WELWYN HATFIELD COUNCIL – DEVELOPMENT CONTROL
DELEGATED REPORT

APPLICATION No:	S6/2010/1121/LU
------------------------	------------------------

The proposal is to raise the height of the roof above the existing side extensions comprising of the reading room and two en suite bathrooms by a further 1.14 metres to be in line with the height of the roof of the original dwelling house.

Title  
EXISTING CROSS SECTION A-A

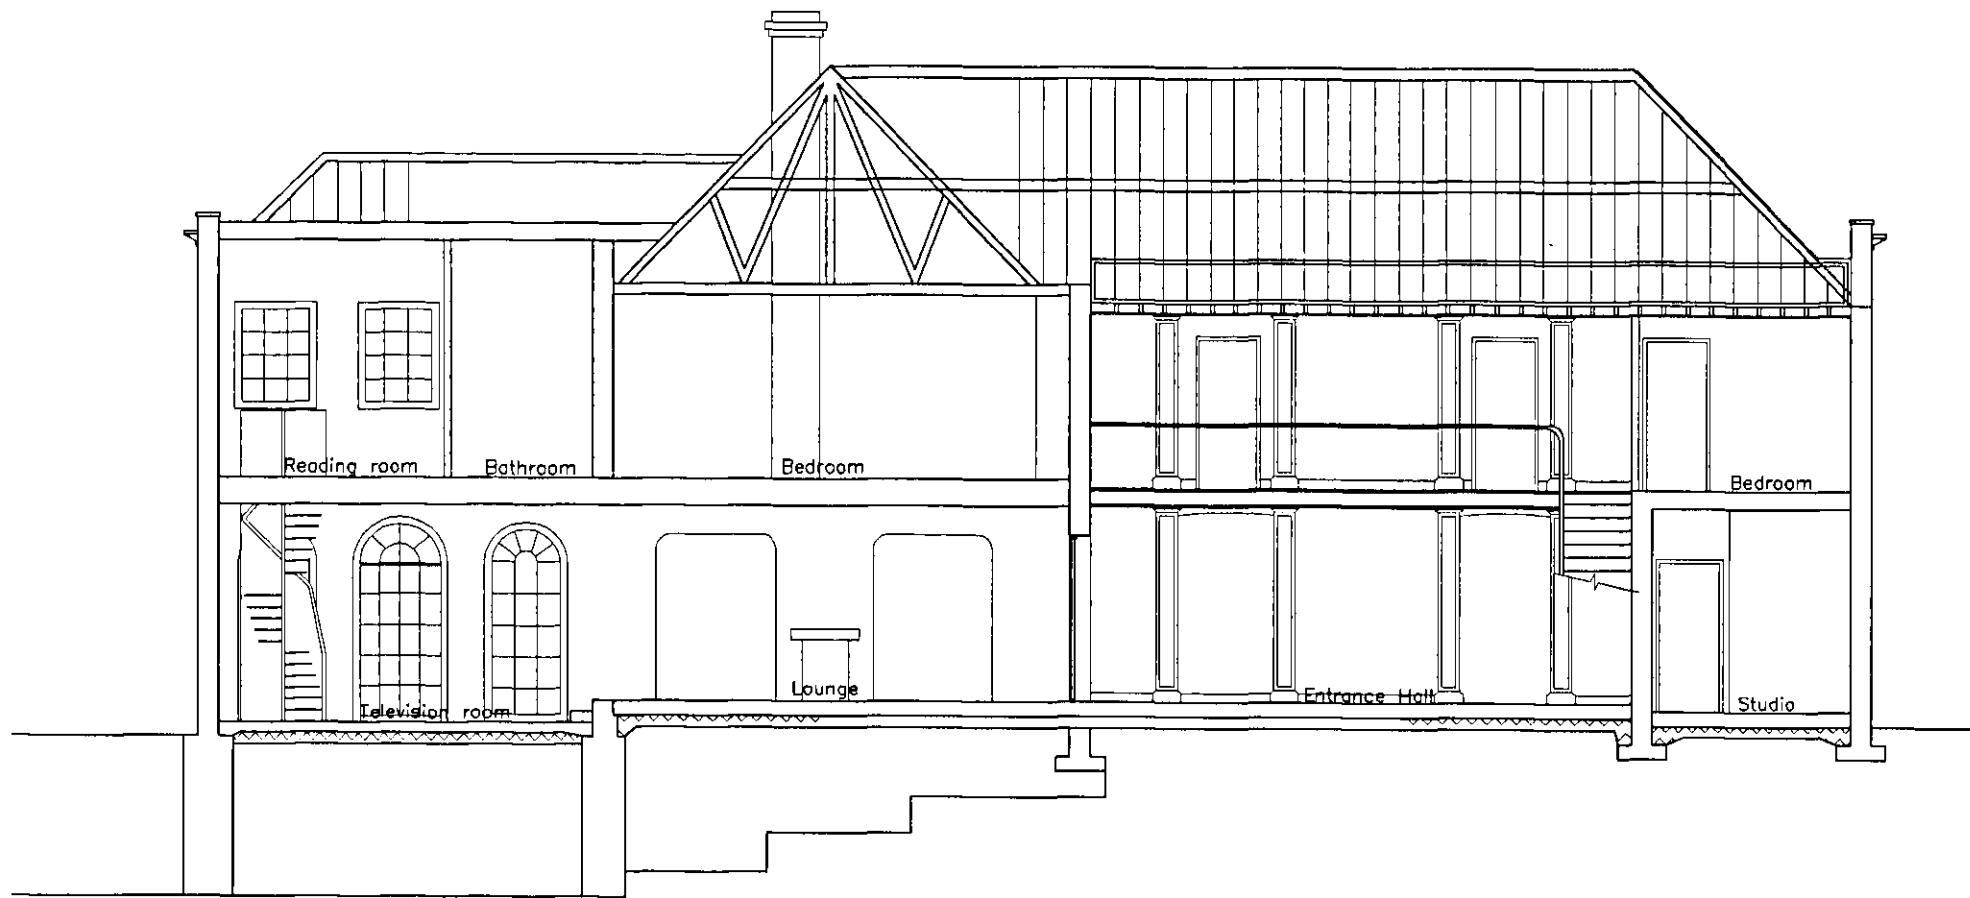
The dwellinghouse has been extended upon previously including an increase to the roof space of the original dwellinghouse. The scale bars on the submitted plans are slightly off scale and therefore the volume measurements have taken this into consideration.

Existing extension to roofspace: length 5.46m x depth 5.4m x height 0.98m = 28.8m³

Title
PROPOSED CROSS SECTION A-A

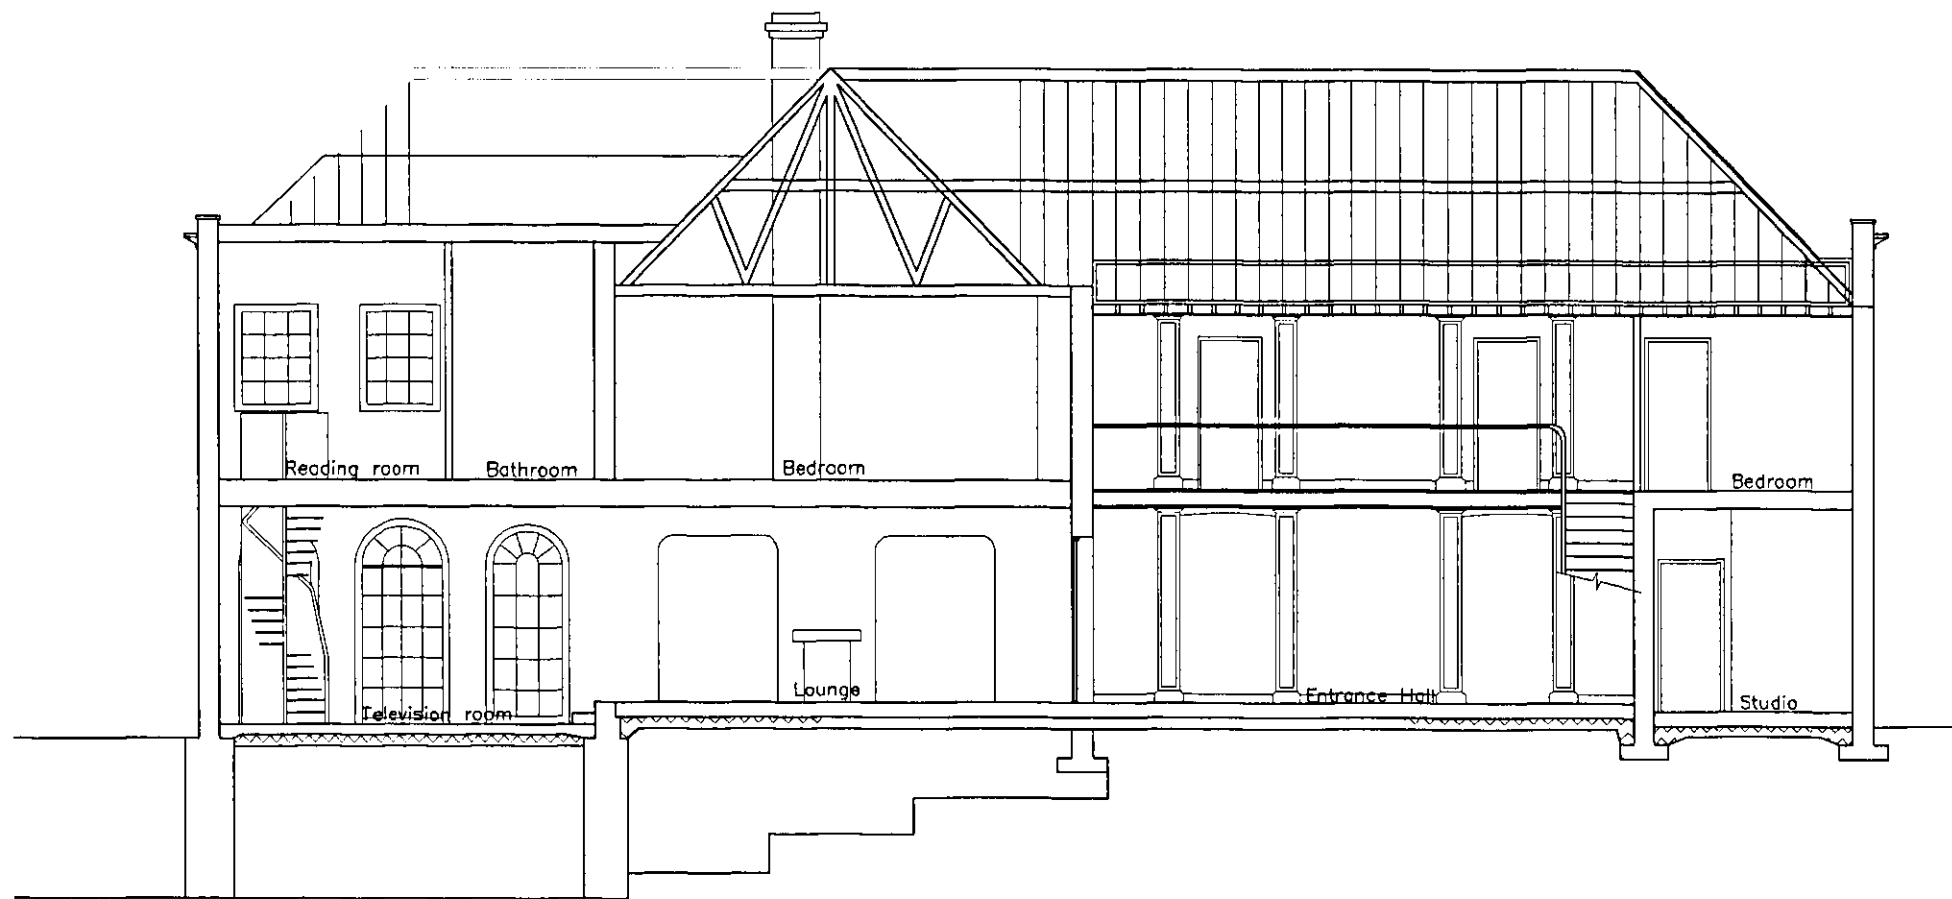
Proposed extension to roofspace: length 5.4m x depth 3.32m x height 1.24m = 22.2m³

Total additional roofspace to original dwellinghouse: 28.8m³ + 22.2m³ = 51m³

The proposal therefore fails to comply with Class B (c) (ii) by virtue of the additional roof space being more than 50 cubic metres.

Title:
 PROPOSED ELEVATIONS

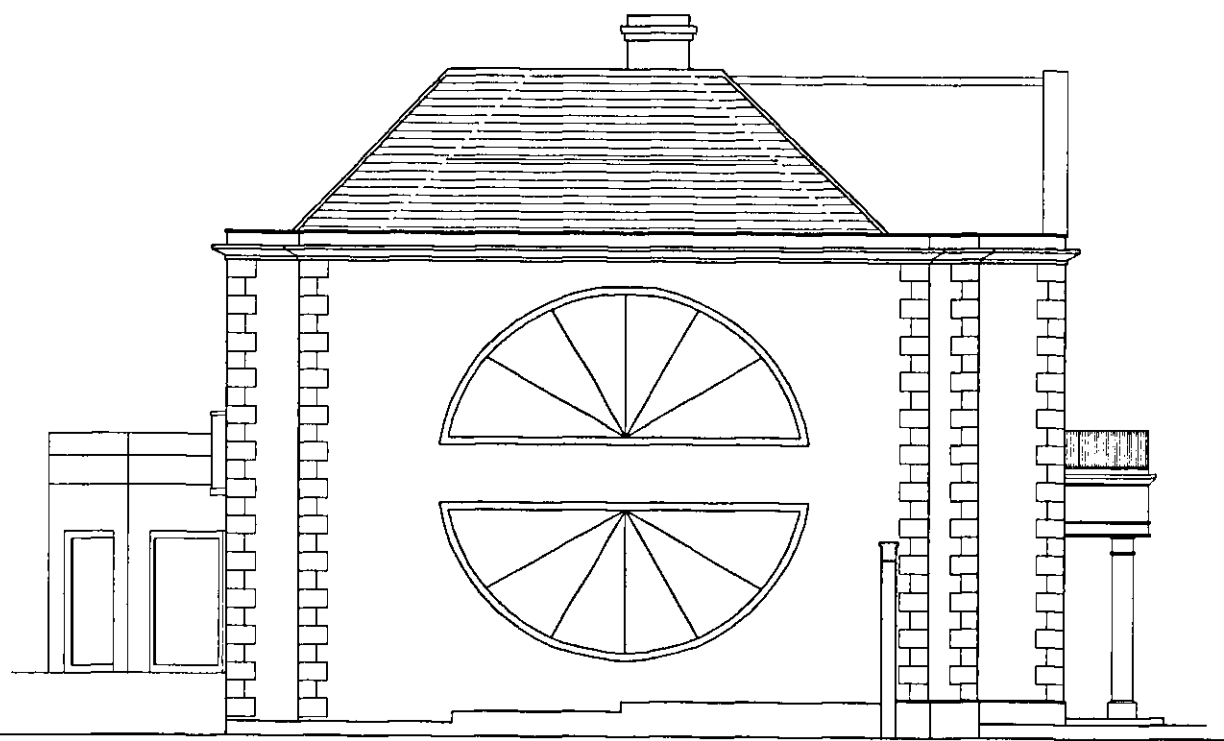
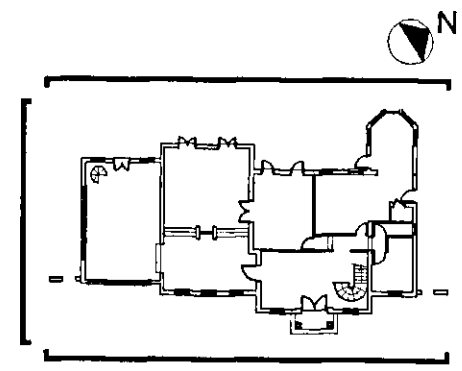
As a result of the works, the dwellinghouse would not exceed the height of the highest part of the existing roof.

The proposal does not extend beyond the plane of any existing roof slope which forms the principal elevation of the dwellinghouse and fronts the highway.

The edge of the enlargement closest to the eaves of the original roof would not be less than 20 centimetres from the eaves of the original roof.

No windows are proposed.
